Department of Primary Industries

27 March 2013

PART 3A CONSULTATION – MOONEE PARKLANDS

- CATCHMENT BOUNDARY
- CATCHMENT I.D.
- GROSS POLLUTANT TRAP
- EXTENT OF PROPOSED BIOREMEDIATION BASIN

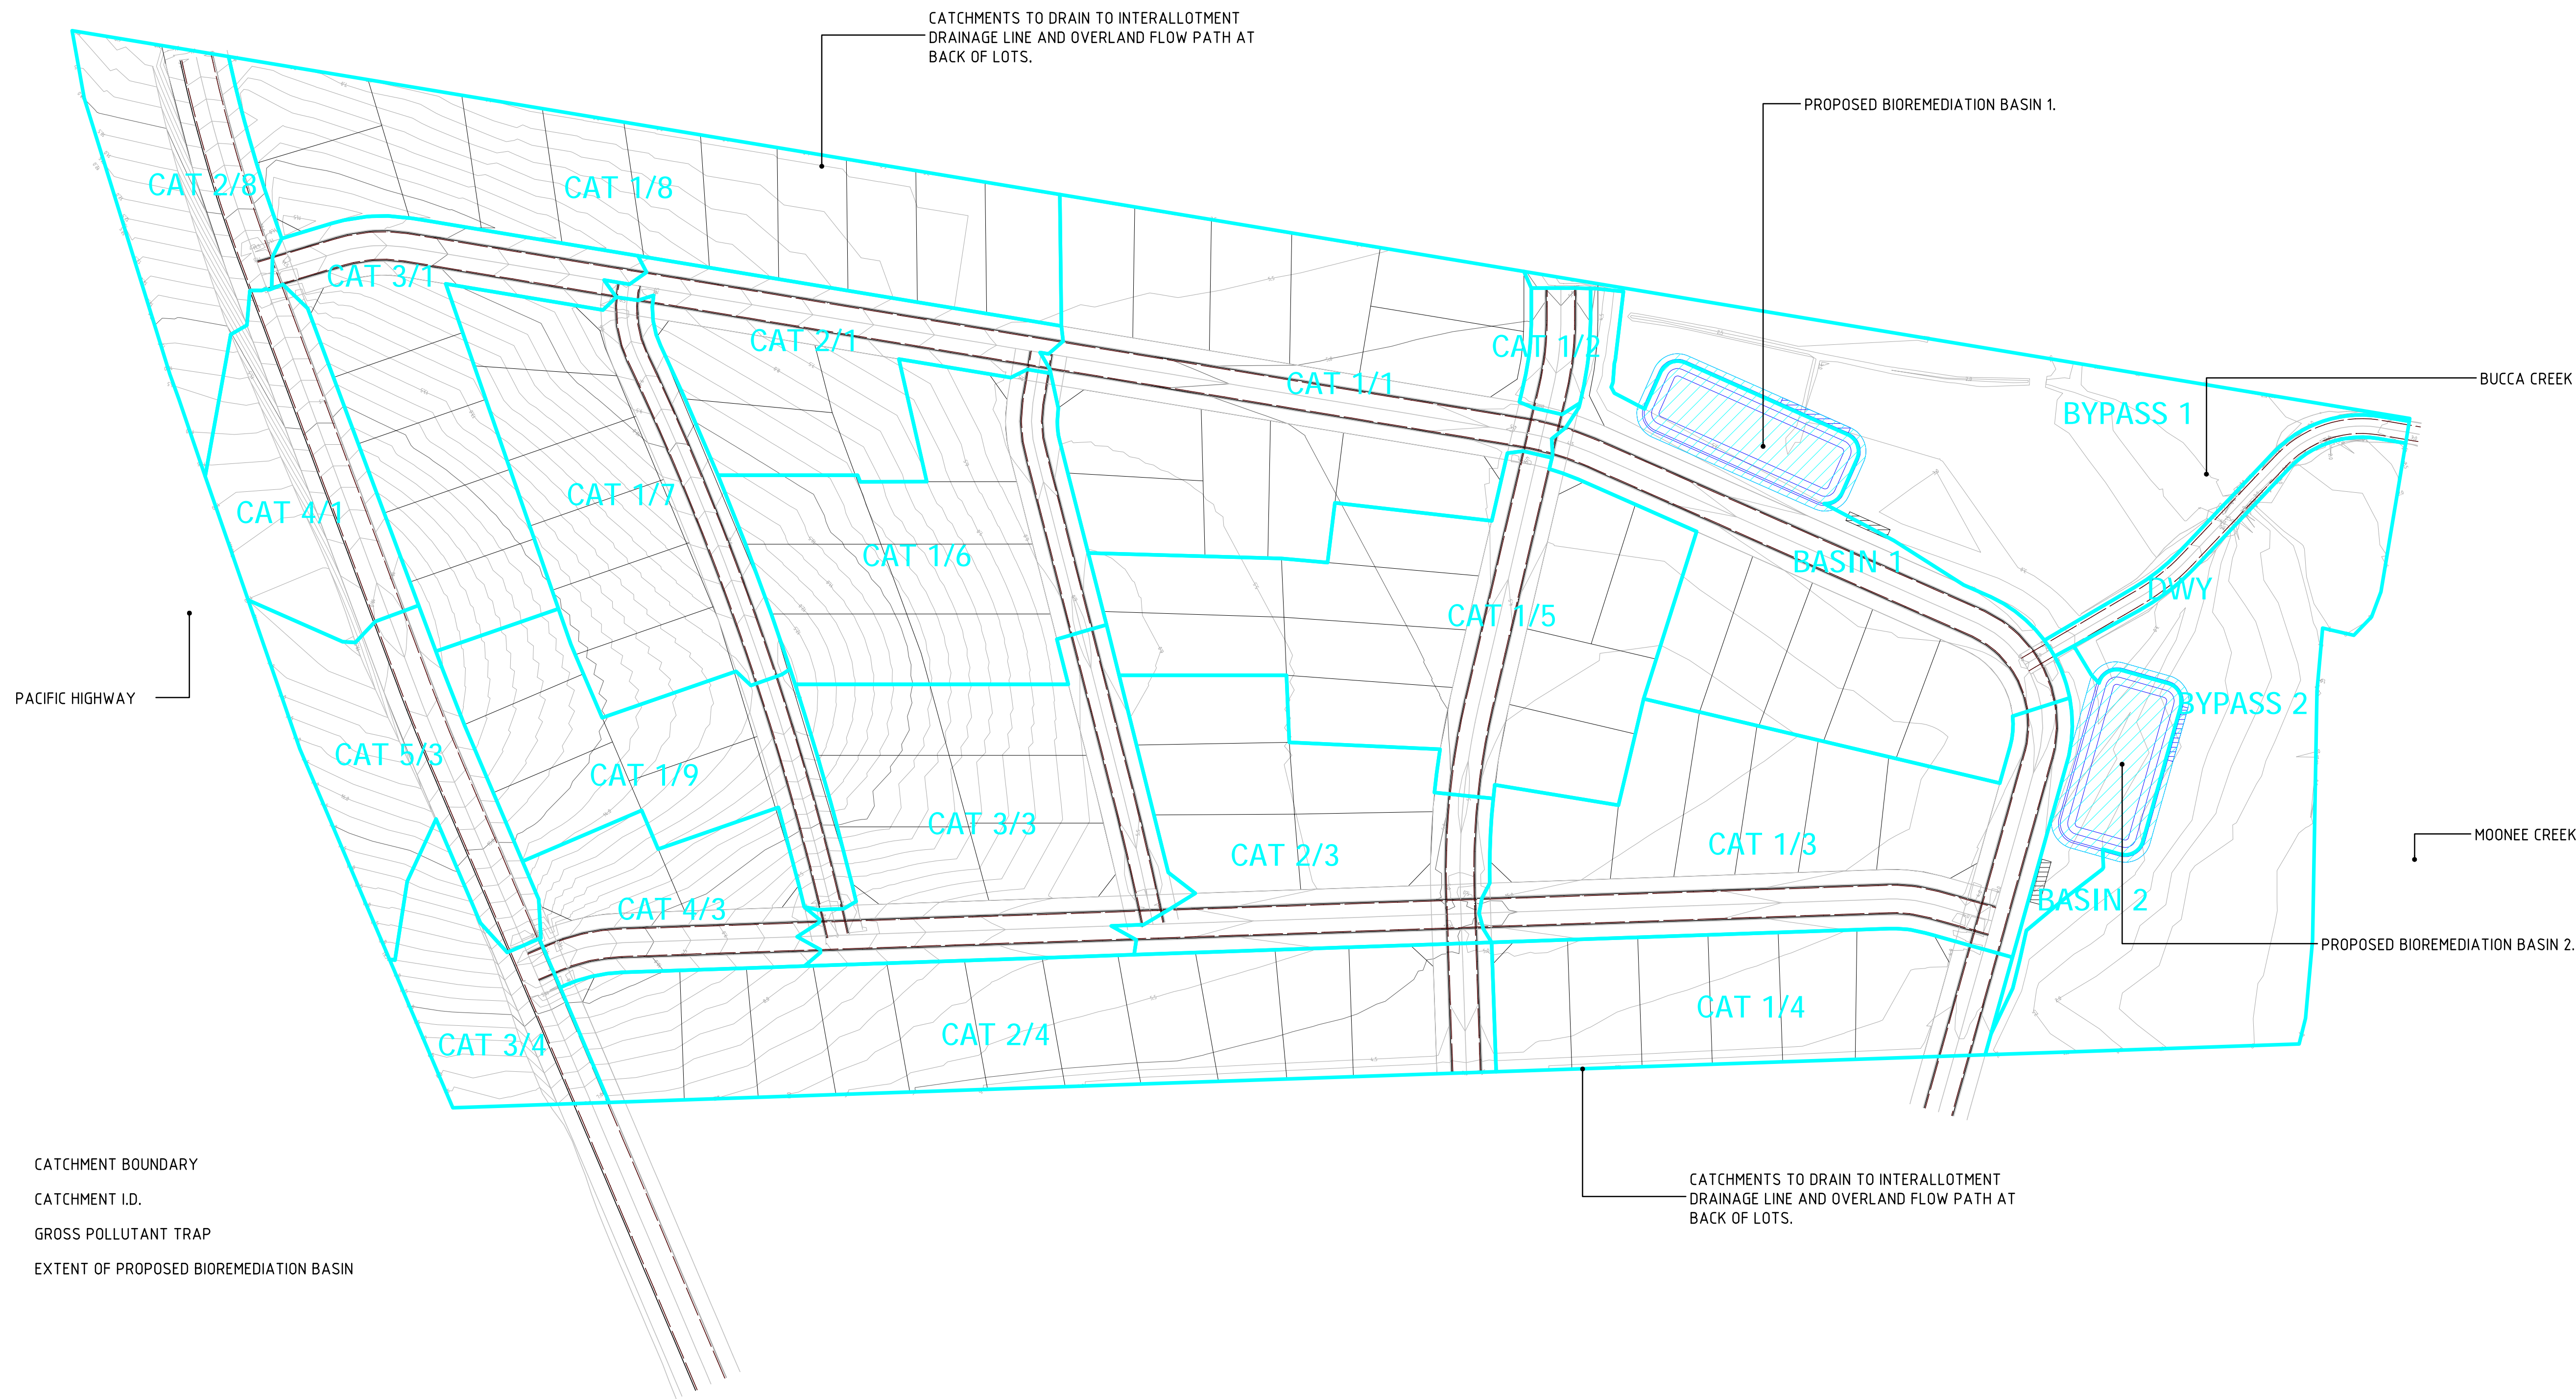
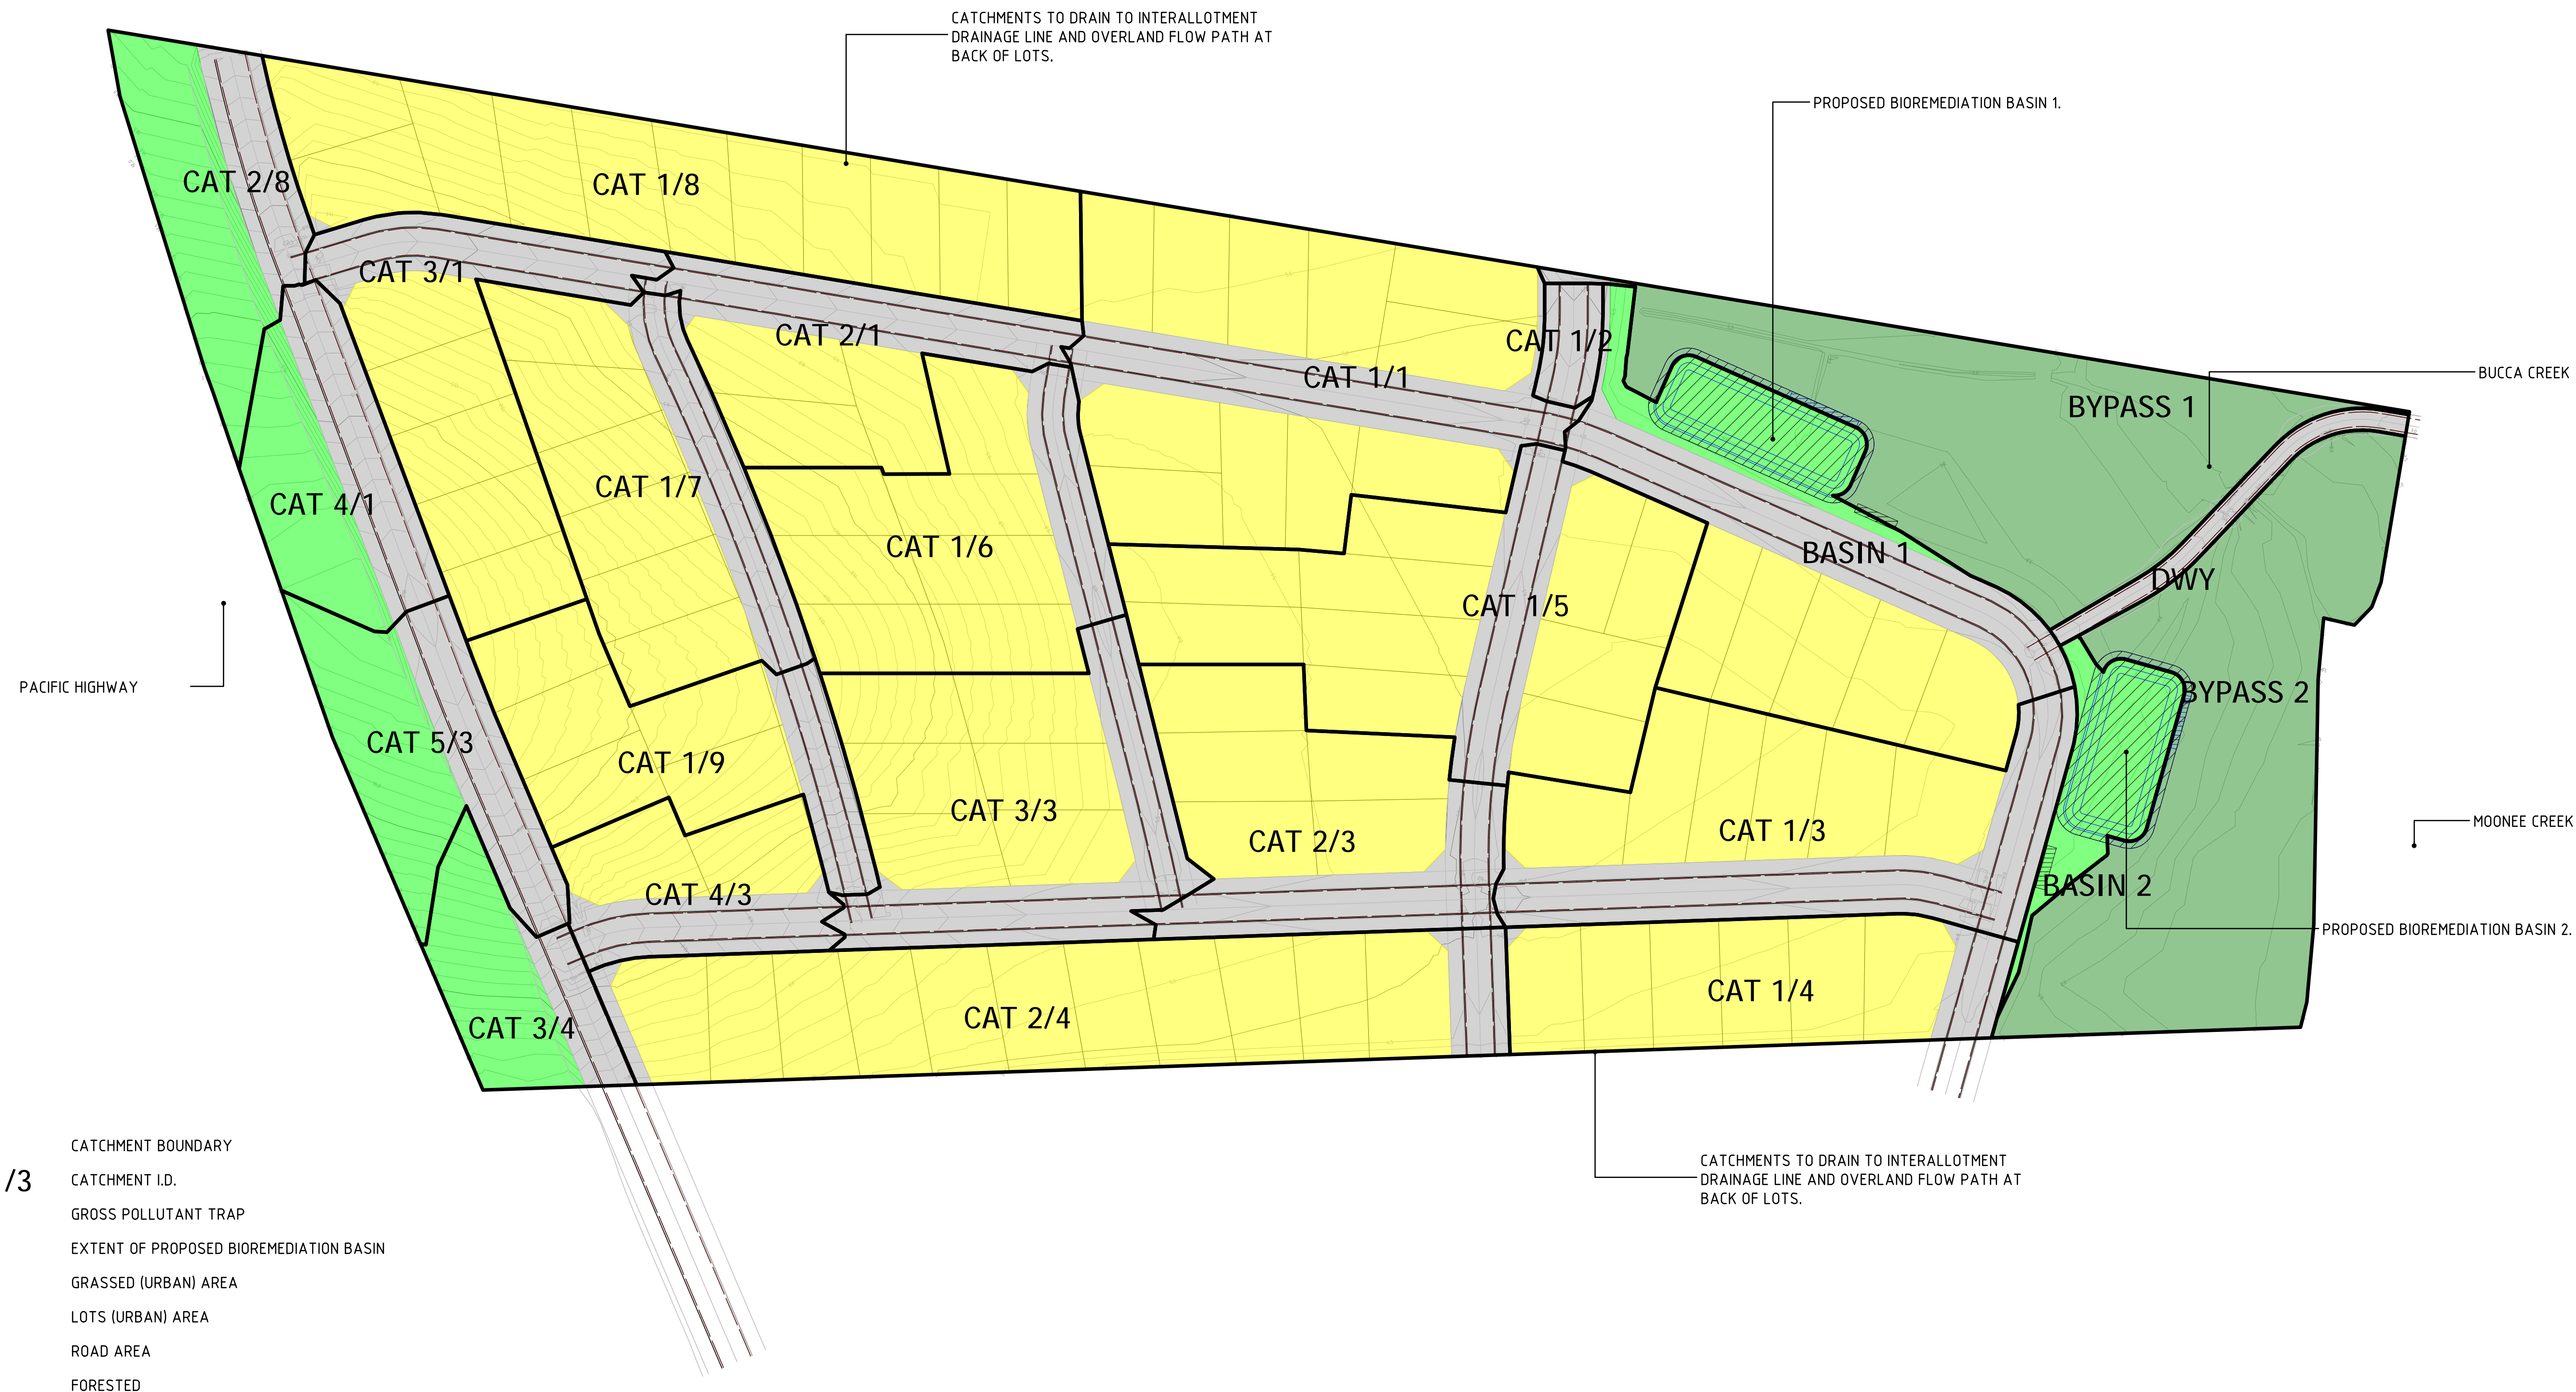
The Concept Site Plan in the Flood Assessment appears to also show proposed bioremediation basins located within the area zoned 7A and in an area that is also at risk from future coastal and inundation hazards.

It is the opinion of the Department of Primary Industries – Marine Parks (DPI) that infrastructure such as sewer pump stations and stormwater treatment measures should be located well away from potential future coastal and inundation hazards. It is also the DPI's opinion that infrastructure related to the development should not be located within areas set aside for environmental protection as this may reduce the effectiveness of the area in providing a buffer between the development and Moonee Creek.
